COMMUNITY DEVELOPMENT DEPARTMENT  
501 Delta Avenue ♦ Marysville, WA 98270 ♦ (360) 363-8000

Re: Bazara Short Plan - *Final Review 1*  
SP23-004

After reviewing the Final Short Plat, the following comments will need to be addressed:

SHEET 2 OF 2
SCALE 1"=20'
SURVEYED _____
FIELD BOOK _____
DRAWN VBB
CHECKED CPC
FILE SV-Sp-OWDV0287.dwg

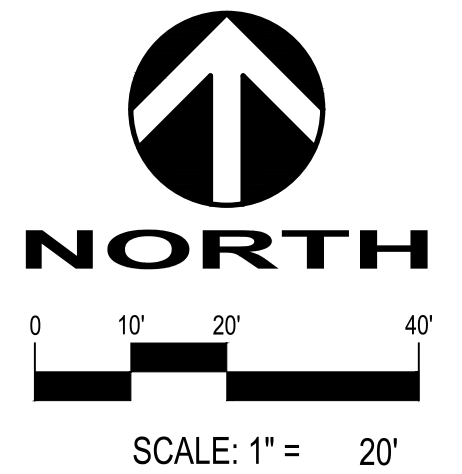
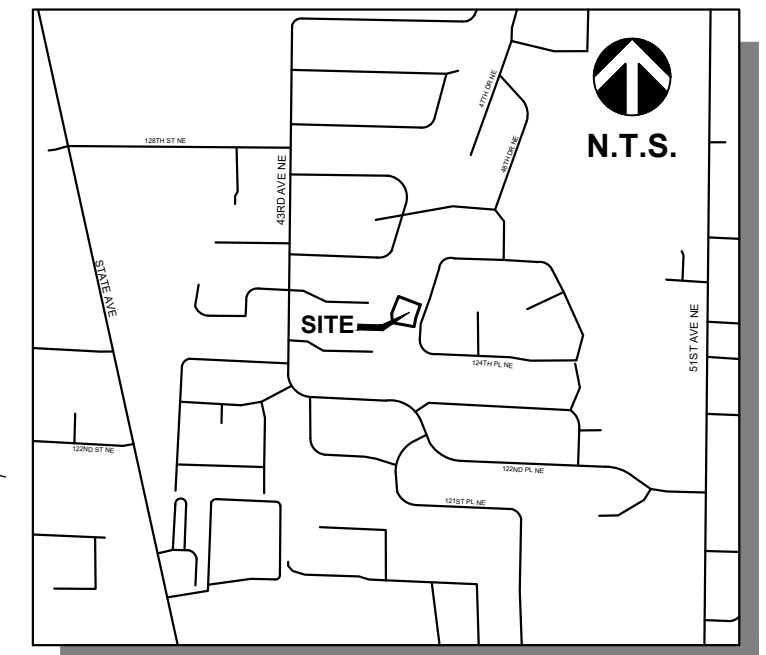
3. Amend sheet 2 of 2, as follows:

a. Add date of survey;

b. Add zoning setback lines for the existing single-family residence and garage lot 1;

- a. Front Yard: 20 ft
  - b. Rear Yard: 5 ft
  - c. Side Yard(s): 5 ft
  - c. Depict existing structures, building setback lines and any encroachments for lot 1;

- d. Location and description of monuments and lot corners must be set and found;
  - e. Remove the carport from the final short plat map;
4. Pursuant to [MMC 22C.120.140\(2\)\(d\)](#) street trees are required to be a minimum of 1.5-inch caliper at the time of planting. Additionally, according to the note in the approved LS Plan the street trees shall be 6 to 8 feet tall and have a minimum diameter of 6" above ground at time of planting, which complies with [MMC 22C.120.140\(2\)\(d\)](#). After conducting a site visit the street trees that were planted are less than 1.5-inch caliper and less than 6 to 8 feet in height. In order to comply with the street tree requirement that planted trees will need to be replaced in order to comply with the street tree size requirement. **the trees will be replaced in sprint with this weater all the plants will not lass long.**

14. Lot 2 curve labels are missing.

**updated on the survey**
